Office of
Environment
& Heritage

I refer to your letter dated 7 August 2012 seeking comments from the Office of Environment and Heritage (OEH) on the Environmental Assessment (EA) for NRE No.1 Colliery – Modification MP10_0046 Mod 1.

Office of Environment and Heritage (OEH) Comment on Environmental Assessment for Gujarat NRE Application for s75W Modification 1 to MP 10_0046 – Preliminary Works Project *Longwalls 4 and 5; Maingates 6, 7 and 8.*

Figure 8 - Swamps with New LW5 Layout

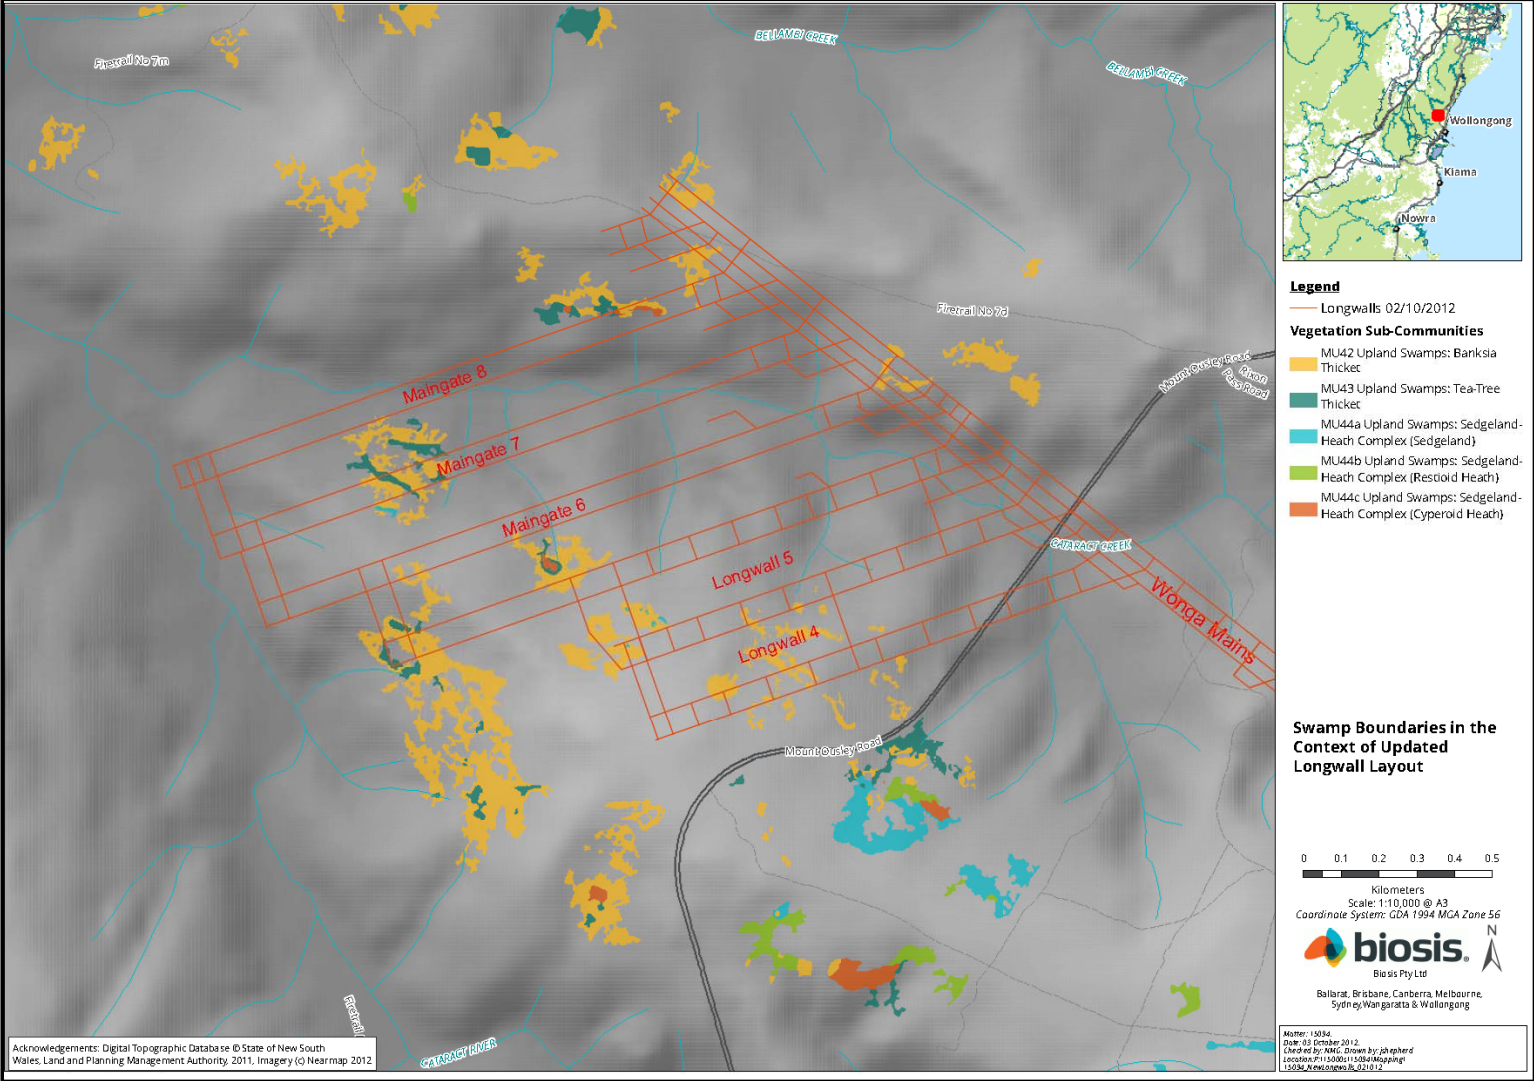
The subsidence predictions for Longwall 5, which undermines upland swamp CCHS3 and is adjacent to CCHS4, clearly exceed these thresholds. Seedsman Geotechnics (2012) predicts maximum tilt at 17 mm/m, with strains anticipated to be between 12 mm/m compression to 10 mm/m tension (Seedsman 2012) in LW5. As such these swamps are clearly at risk of negative environmental consequences from the proposal.

Upland swamps CCHS3 and CCHS4 are natural features of 'Special Significance' and they are clearly at risk of negative environmental consequences from Longwall 5. Given that this application also includes works for Maingates 6, 7 and 8 it is anticipated that further impacts are proposed as a result of additional longwalls to the north. The proposal cannot demonstrate that it can meet performance measures of 'negligible environmental consequences' for these features, which is the best-practice standard currently recognised following many years of detailed iterative investigations and reviews into the impacts of longwall coal mining in the Southern Coalfields.

The upland swamp at greatest risk is identified as CCHS3. Given these upland swamp EECs are identified as such they should be afforded special protection by way of a negligible impact criteria in any mine approval conditions. In order to be able to meet the performance measures the proposal needs to be modified, either by altering the mining parameters (panel width, pillar width) where mining is carried out beneath the swamps of special significance, or by shortening the longwalls to avoid subsidence impacts to these swamps.
